Engineers Comments Regarding Surface Water Drainage

Application Reference:	AL/103/25/DOC	Reviewer Reference:	ADC/EXT4
Planning Officer:	Simon Davis	Date of Review:	13/01/2026
Site Name:	Land Adjacent to Woodgate Nurseries Lidsey Road Aldingbourne		
Application Description:	Approval of details reserved by condition imposed under AL/129/21/OUT in relation to conditions 16-Surface Water Drainage Scheme, 17-discharge flows to watercourses and 18-maintenance and management of surface water drainage.		
Assessment Number:	2 of 2

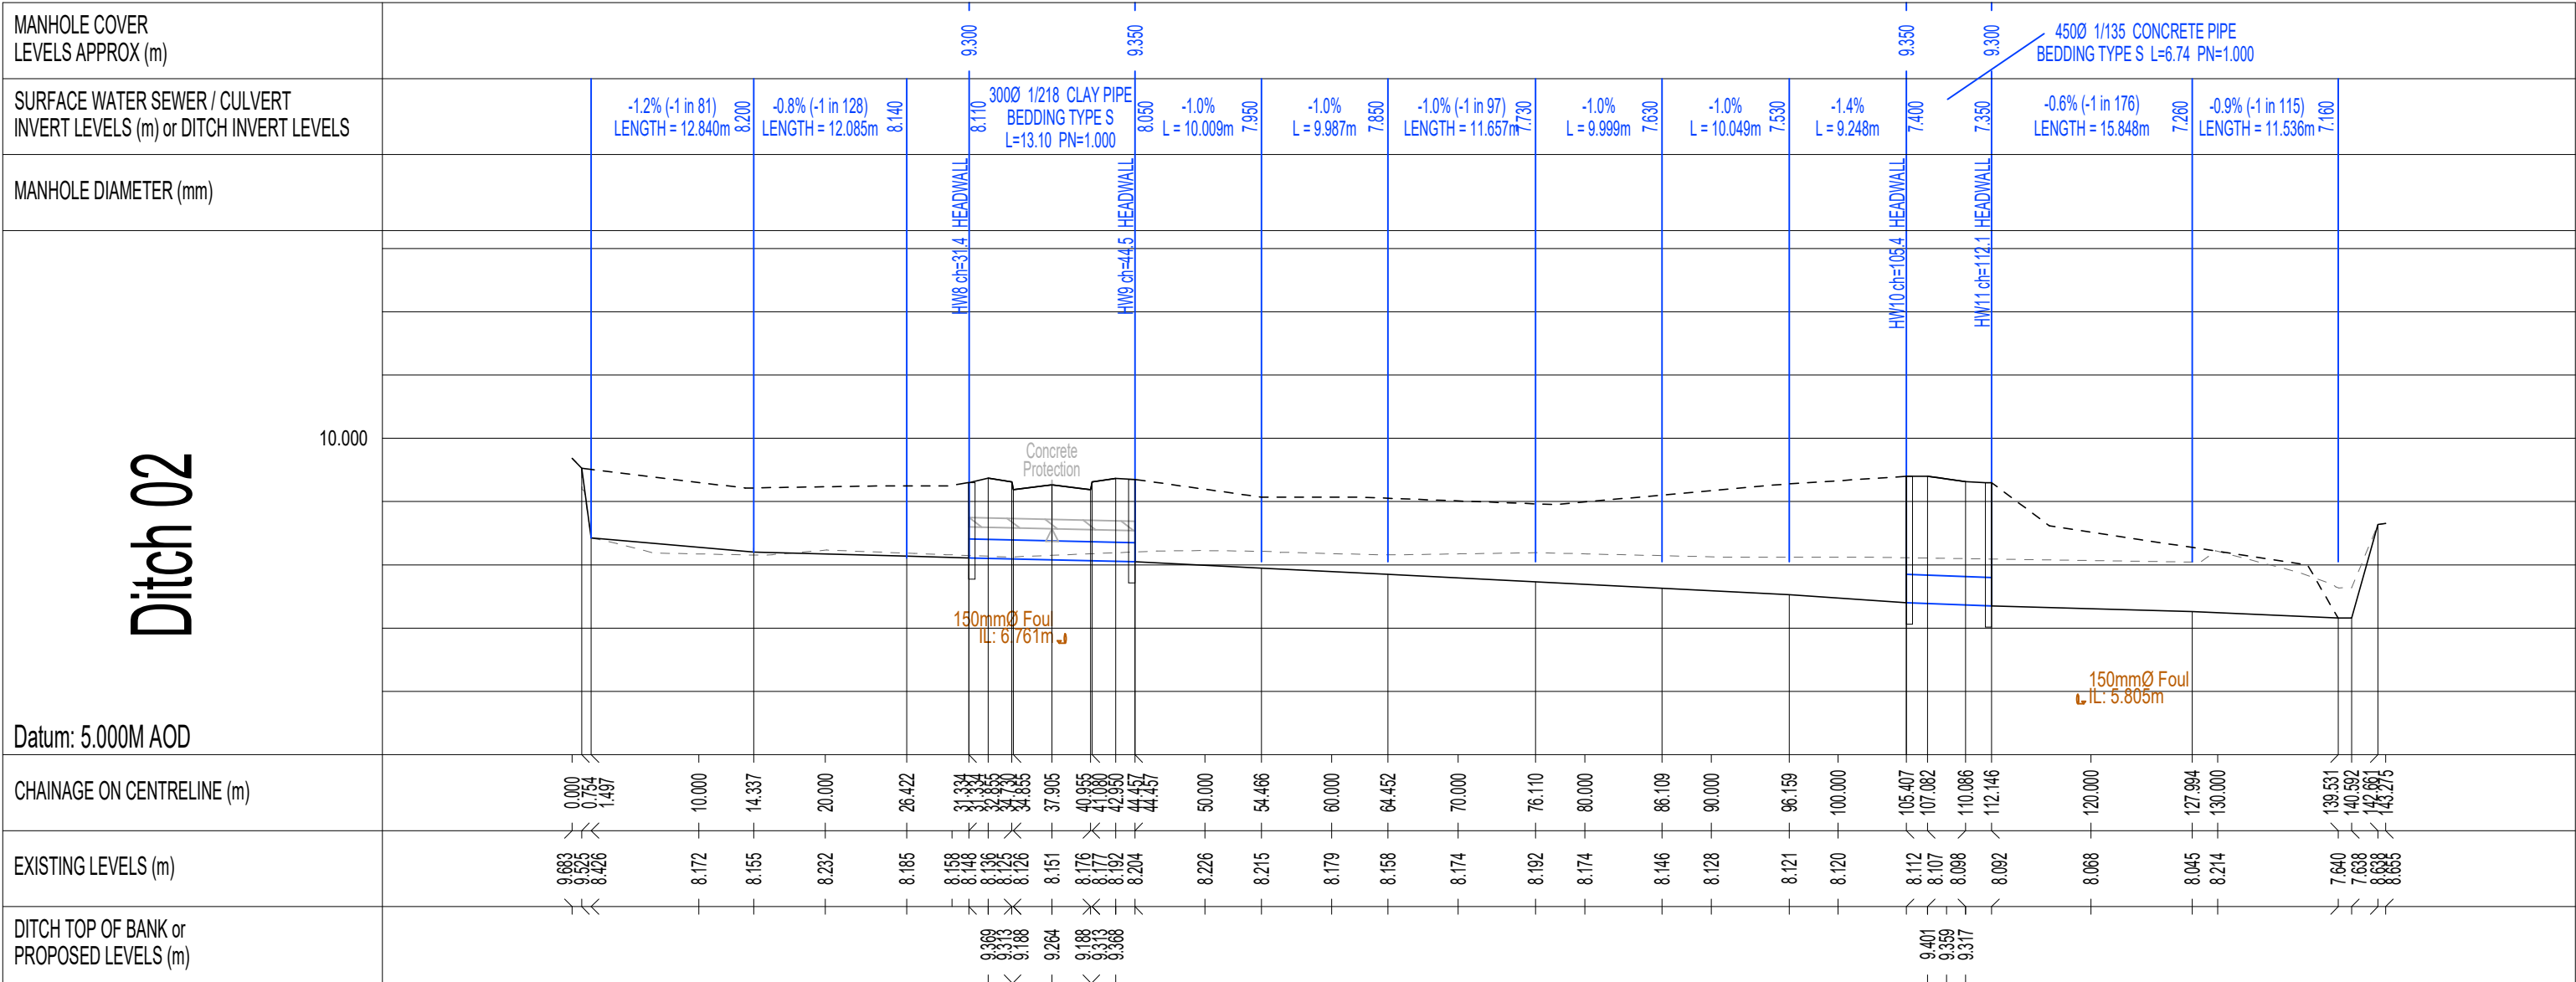
Comment Number					
1	Please note that the proposals for the construction of the new headwall outfalls and culverting of the existing watercourses will require Ordinary Watercourse consents. Please submit the consent to demonstrate no	The drainage layout clearly shows that the headwall encroaches into watercourse, including works to outfall base and erosion control measures. The long section provided noted regrading to the ditch bed level as well. Please	As discussed in recent meeting, Duncan Kier confirmed his view taken as part of the OWC approval that the outfall does not encroach into ditch profile and therefore no OWC was needed He also	Noted item closed

conflict between approved plans. Designer Response 21/10/2025 Please find enclosed Ordinary Watercourse consent for drainage works on the watercourses, that consist construction of culvers / headwalls, regrading of existing ditches. No consent is required for outfall to watercourse as the outfall profile doesn't encroach into ditch profile.	provide construction details of outfall to ditch as well as OWC	confirmed the clearing, de-silting, and regrading of ditches was viewed as watercourse maintenance which also does not require OWC. Within the same meeting		
2	Please provide evidence of positive dialogue in relation to the proposed culvert of the watercourse, in terms of capacity assessments and confirmation of ecological and tree protection impacts or mitigation. Some of the proposed headwalls appear to conflict with existing trees and potentially lie within root protection areas of trees. Please provide details of tree removal plan as well Designer Response 21/10/2025 The ordinary watercourse consent on the culvert has	Provide details of design and drawings which have been approved by this OWC	Approved OWC drawings included in resubmission.	Noted item closed
